Our Case Number: ABP-318573-23

Re: A proposed Road Development comprising of the N2 Slane By-Pass and Public Realm Enhancement Scheme
Within the Townlands of Slane, County Meath

Oifig na
nOibreacha Poiblí
Office of Public Works

RE: N2 Slane Bypass and Public Realm Enhancement Scheme

Figure 13.31: Viewshed from Knowth, with Proposed Scheme Alignment Shown in Light Purple (Viewshed produced using Digital Surface Model, which shows surface features such as trees & hedges)

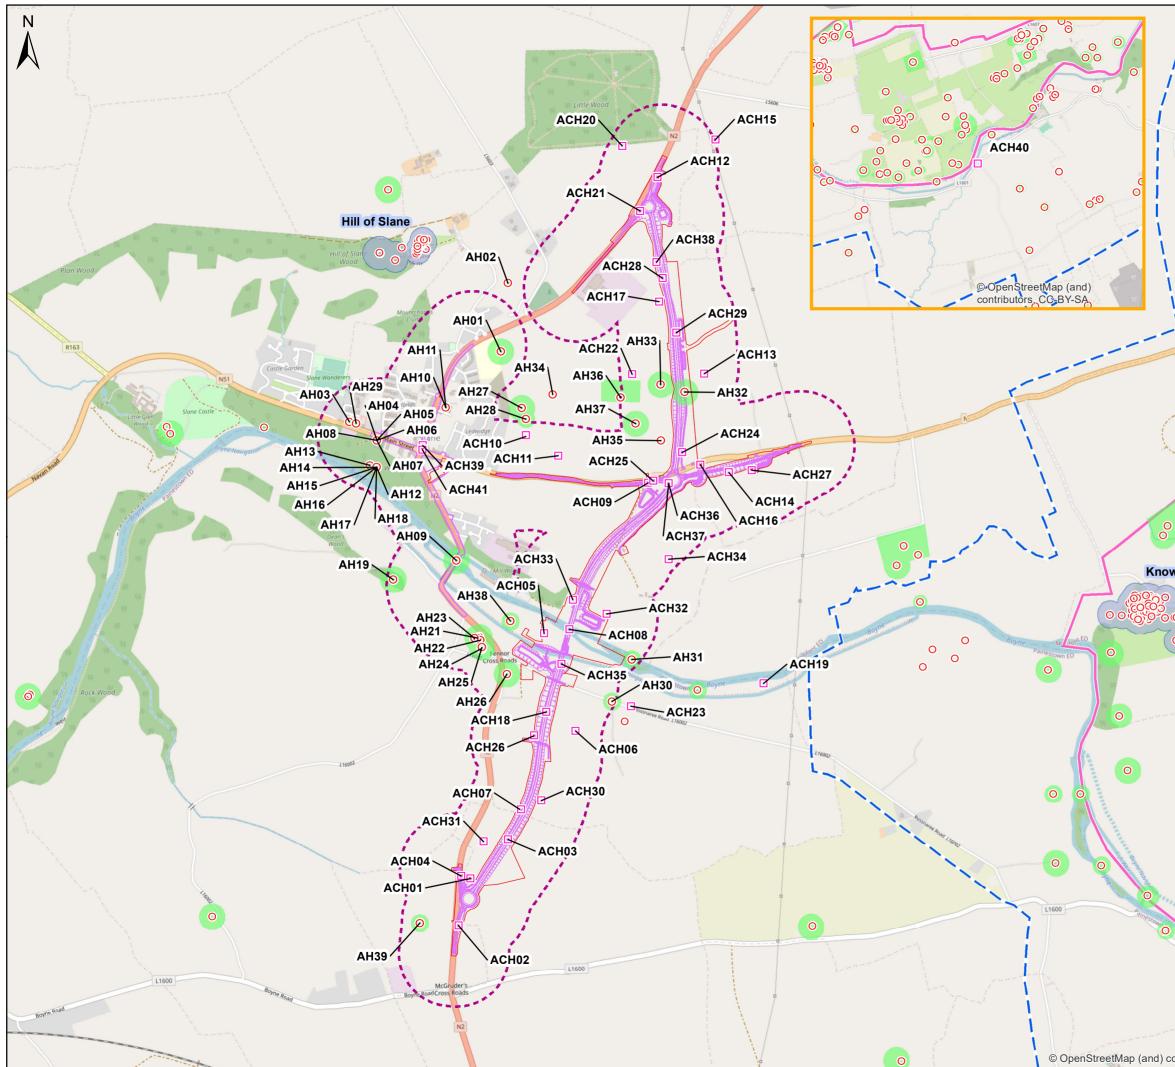
The HIA Statement of Significance identifies the land around Slane as forming a backdrop to views from within the WHP, and views to the WHP from the area around Slane as supporting the OUV of the WHP. It defines how Protected View PV59 from Knowth along the Boyne Valley and towards the Hill of Slane supports the OUV as follows:

Specific measures in the scheme design to reduce the impact on OUV in the view from Knowth are as follows:

- The design of the proposed N2 Boyne Bridge – keeping it low in the landscape through use of cuttings, shallow profile, steel which will weather to a dark brown colour
- Use of cuttings to partially conceal the road
- Use of an acoustic bund on the east side of the southern abutment of the proposed bridge
- Planting of new hedgerows with trees on the top of cuttings to mimic field boundaries
- The avoidance of fixed lighting on the south side of the bridge (reducing visibility of lights at periods of low daylight and at night)

Part of the mitigation strategy is that increasingly, over a period of 10 years, the hedgerow planting with trees will conceal high-sided vehicles on the road to the south of the proposed N2 Boyne Bridge. The OPW notes that the positioning of the proposed N2 Boyne Bridge has reduced the visibility of it to 35 metres on Year 1 of the southern end of the bridge and the southern abutment, reducing to the 25 metres of bridge 10 years later. The 10-year photomontage (VPT 01) demonstrates that it is not feasible to screen the view of vehicles crossing the proposed bridge. It is unclear to the OPW, what a structure at higher level is within the photomontages, possibly the Rossnaree overbridge, which is mostly screened in the Year 10 photomontage. The sinking into a cut of the N2 approach to the bridge reduces the visual impact on Year 1; planting will progressively conceal the upper parts of high-sided vehicles over a 10-year period.
